Re: Smeaton Grange SSD 7424 Modification 1 Amendment - Condition B61

This letter is in response to your email dated 13 August 2018 regarding Camden Council's (Council) response to the SSD 7424 Modification 1 application (modification), currently being considered by the Department.

FRONT FENCE DETAIL PLAN  
SCALE 1:200

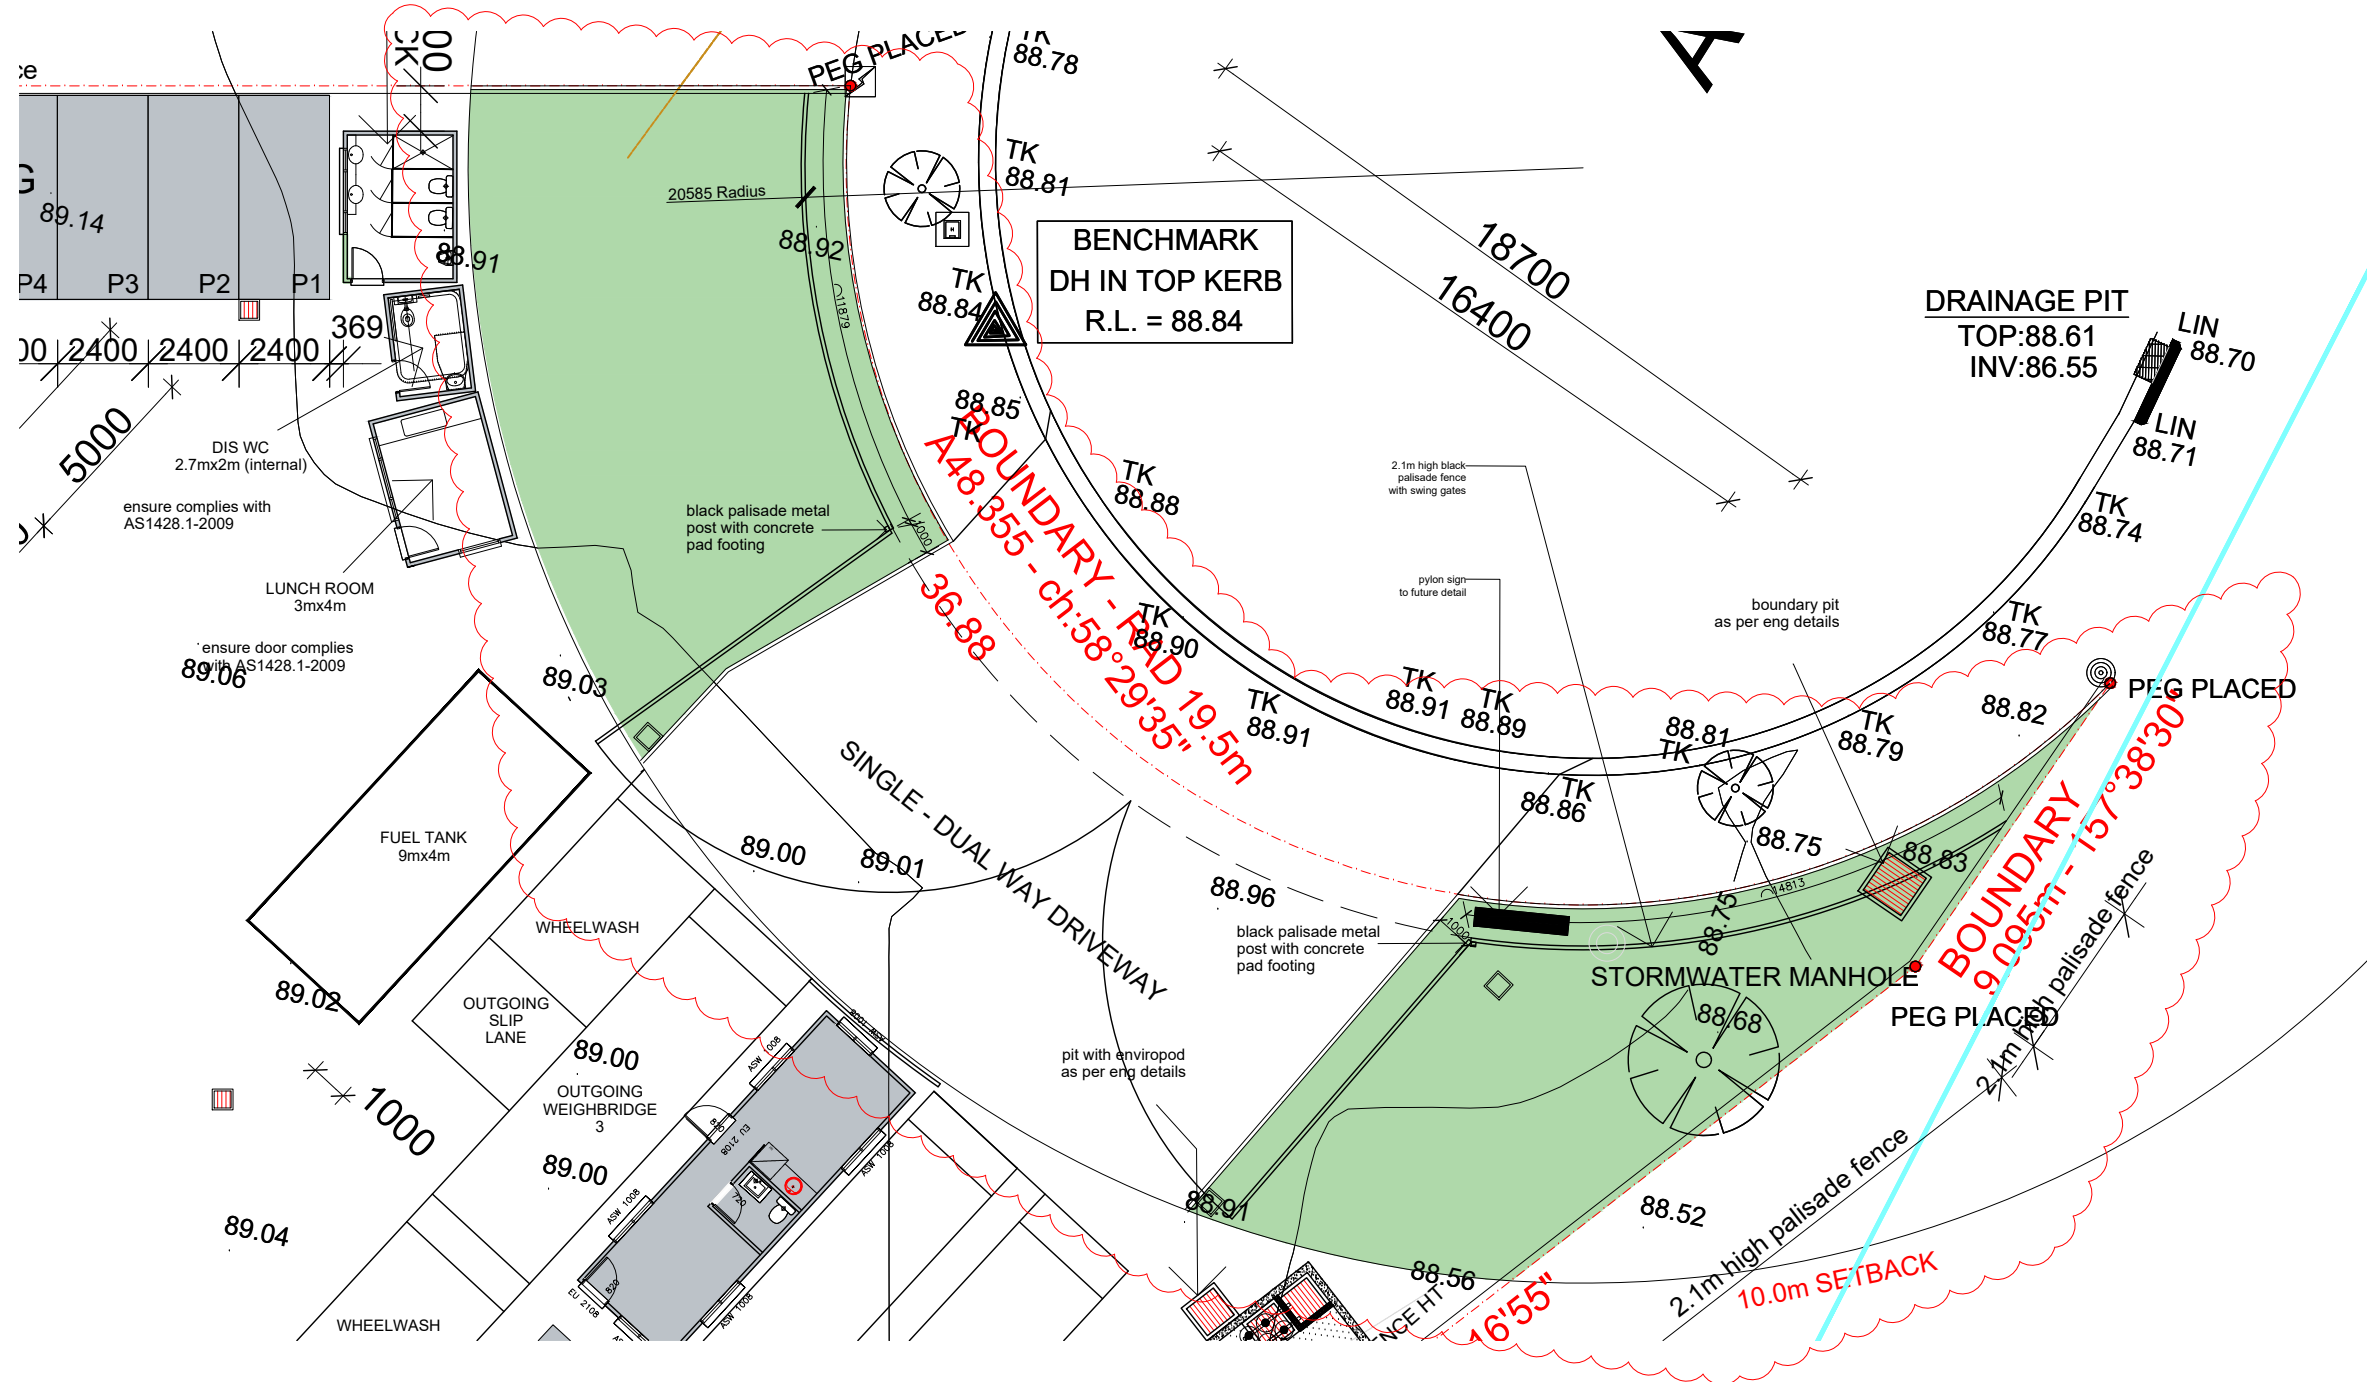
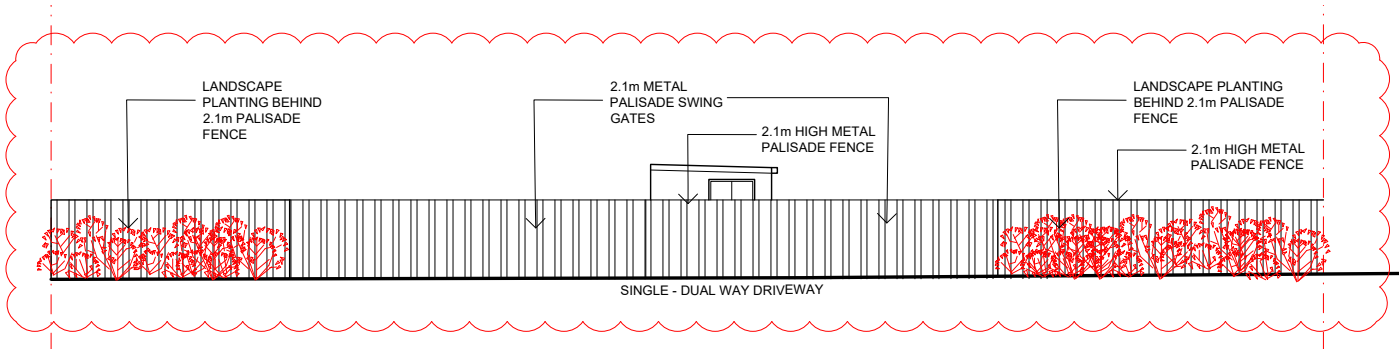
1. A decorative masonry fence is preferred for visual screening.
2. Landscaping treatment within the 1 m setback is preferred.
3. Mature plantings may provide sufficient visual screening.
4. The proposed fencing treatment generally complies with Council's Development Control Plan (DCP).
5. Council should not be an approval authority for the site security elements (ie Condition B61).

We do not agree that a solid wall and gate at the front of the site would significantly ameliorate views to the site for the following reasons:

- The site is offset from the Anderson Road visual corridor and cul-de-sac. There are negligible views to the site until the cul-de-sac is entered.
- The gate into the site will be open during the day, meaning that there will be clear views into the site regardless of the material of the fence.
- As noted in Council's submission mature vegetation 'may' provide sufficient visual screening. We note that the height for the screening vegetation is generally expected to be between 2 m to 4 m, and will provide suitable screening.

The DCP prioritises 'safer by design' principles for fence design. A key component of these principles is clear sight lines. This is beneficial for public and site security. Maintaining some sight lines will help ensure that there is an opportunity for passive surveillance onto the road and into the site, compared to the complete obstruction of solid fencing and gates.

A visually permeable fence would also maintain safety for any pedestrians, with clear sight lines between the drivers and pedestrians.

Additional screening within the 1 m setback is proposed to increase general visual amenity at the Anderson Road cul-de-sac. The landscaping plan at Figure 1 includes additional landscaping within the setback and would be implemented via the Landscape Management Plan (Condition B58/B59) as part of the modification. We believe that this will enhance the site and lead to positive outcomes for the area.

For all of these reasons, we believe a black palisade fence and gate at the front of the site should be approved.
